# CITY OF ALBUQUERQUE

RE: **Jackson-Wink MMA Academy**  
**Grading and Drainage Plan & Report**  
**Engineers Stamp Date 5/8/15 (K14-D005)**

RE: **Jackson-Wink MMA Academy-Phase 1**  
**301 Martin Luther King Jr. Ave NE**  
**Request Permanent C.O. – Not Accepted**  
**Engineers Stamp Date 5/8/15 (K14D005)**  
**Certification Dated: 6/16/15**

DATE
05/08/2015
SHEET NUMBER
C-1.0

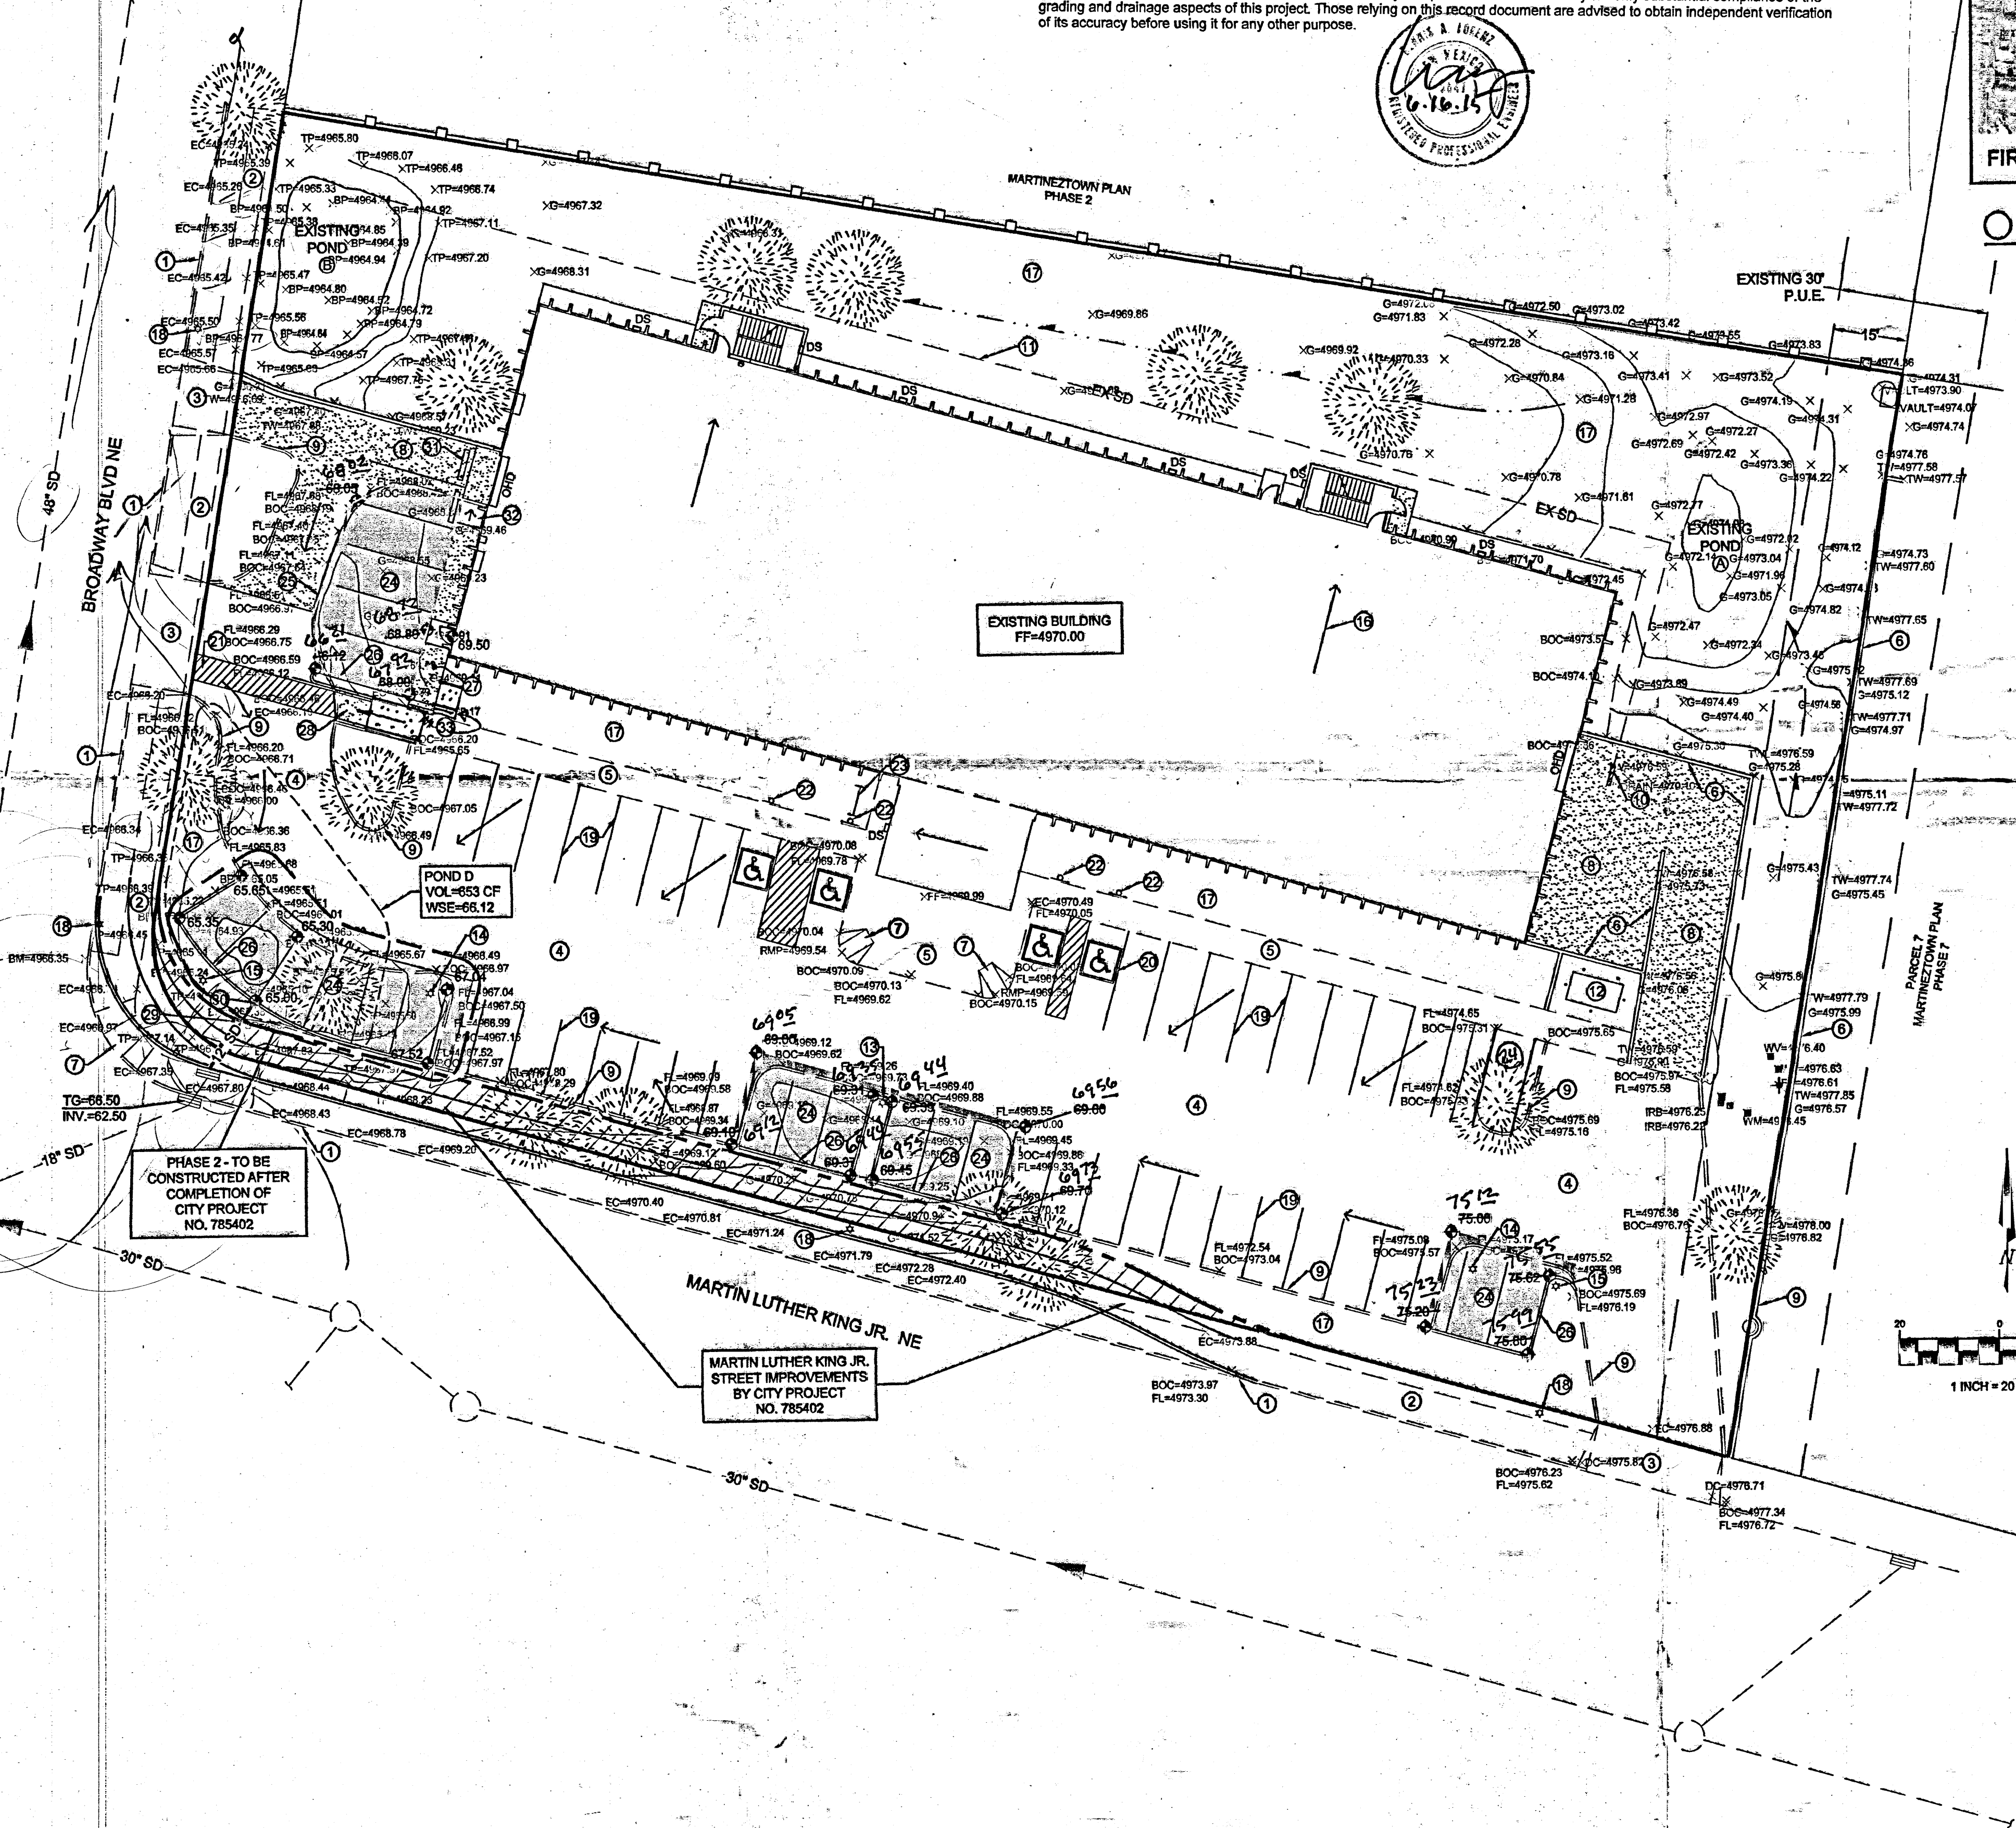
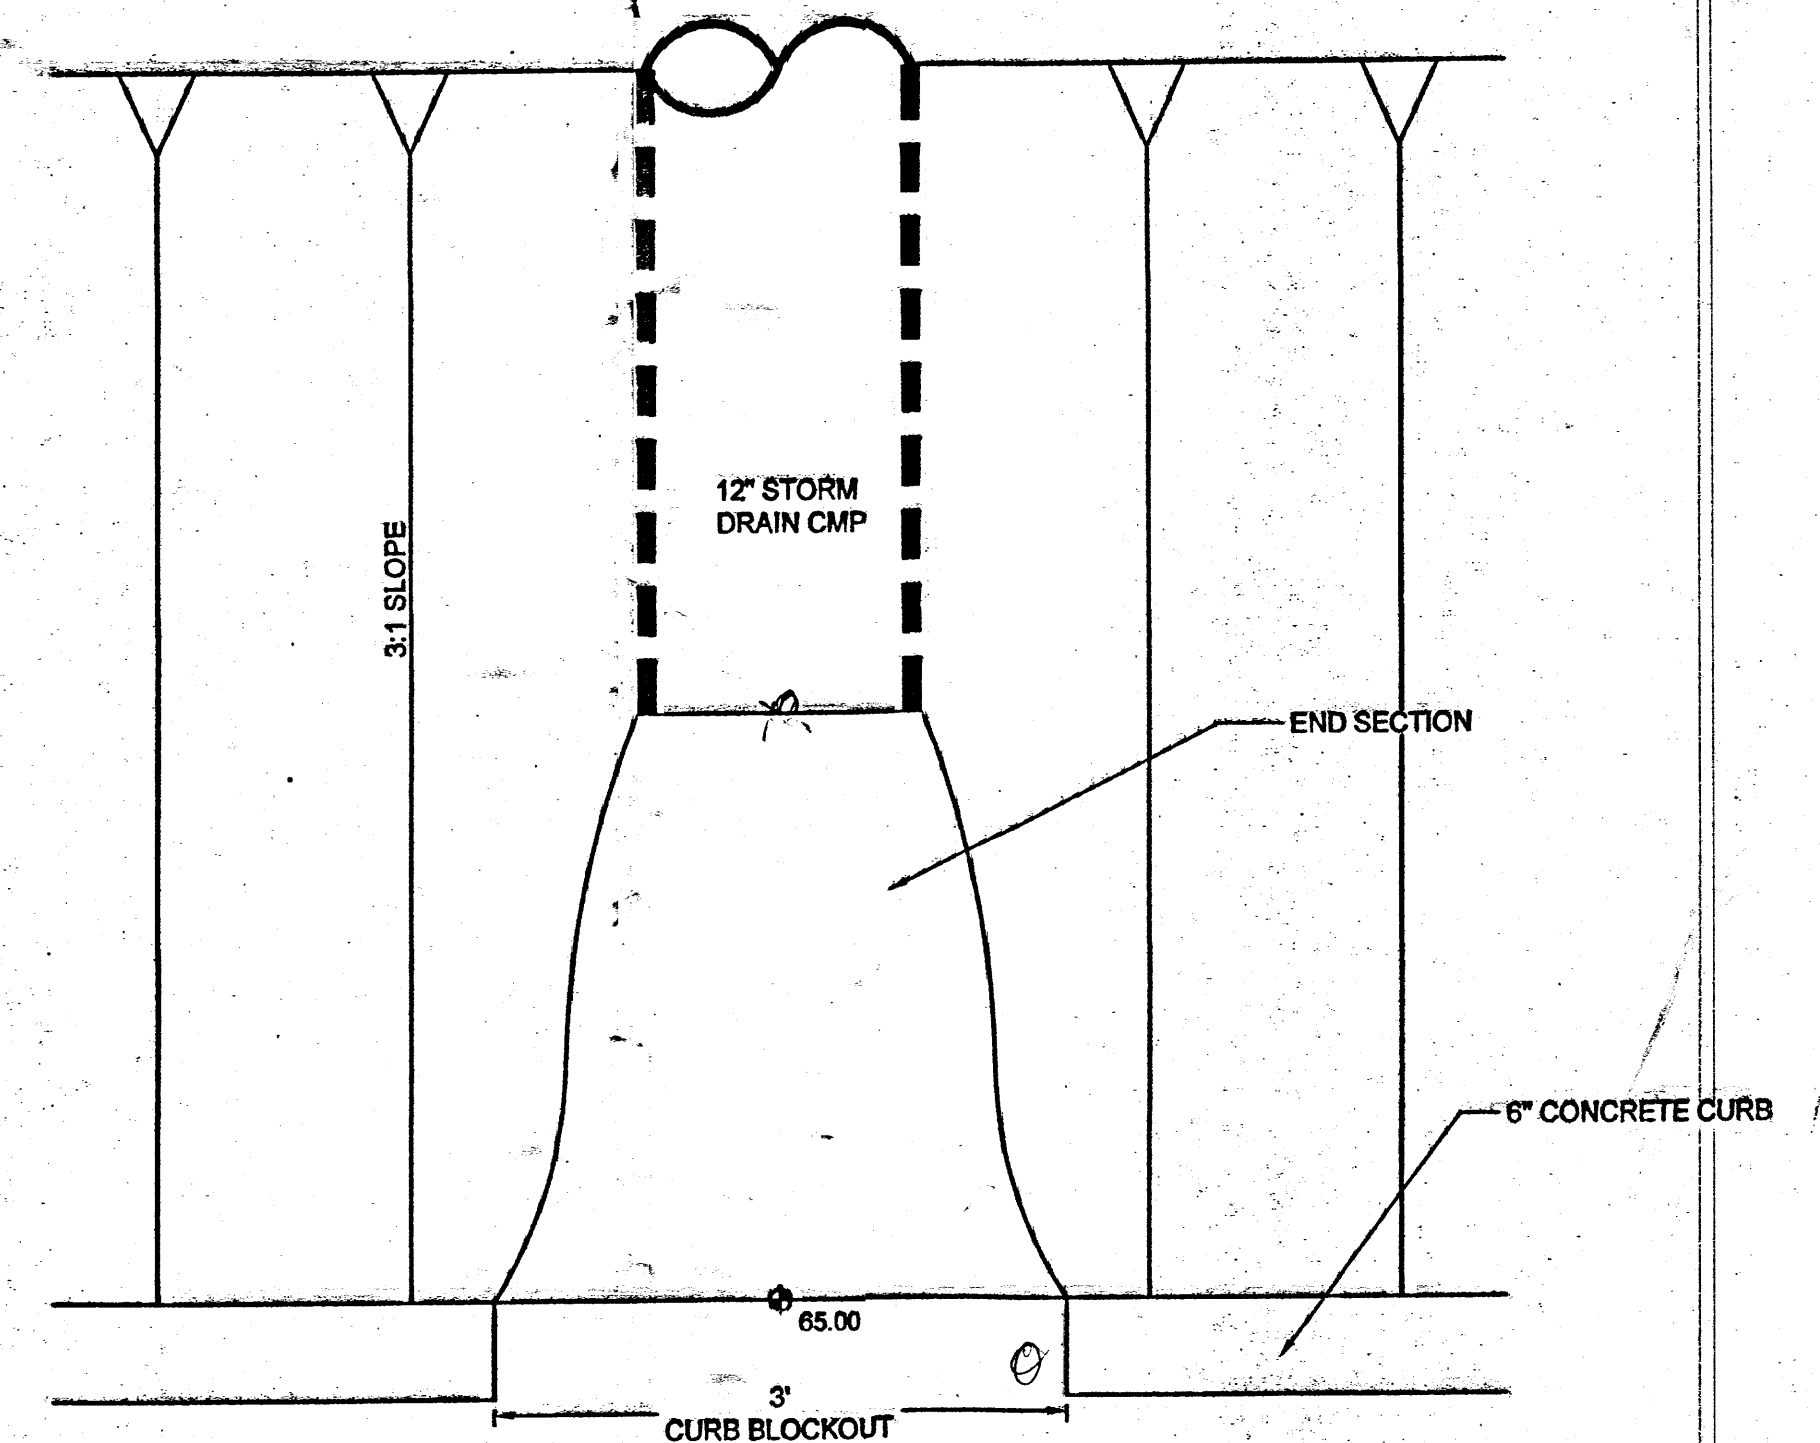
- The flows leaving the south side of the structure need to pass through a landscape buffer before leaving the site via the proposed 12" pipe into the storm sewer system. The 12" pipe should be extended into the landscape area, which is to remain, with a stand pipe and beehive cap.

- This plan dated 5/8/15 was not approved for building permit. The plan dated 2/13/15 was approved for building permit. This is the plan which should be certified.
- The plan dated 5/8/15 needs to address the previous comments provided on 6/9/15. Also, provide an emergency spill way at the north end of the pond directing flows toward Broadway heading north to the pond at Broadway/Lomas.
- Removing the pond as is does not allow for first flush requirements and inundates MLK Jr. Ave., which in turn creates problems in Tijeras at the under pass directly under the rail road tracks.
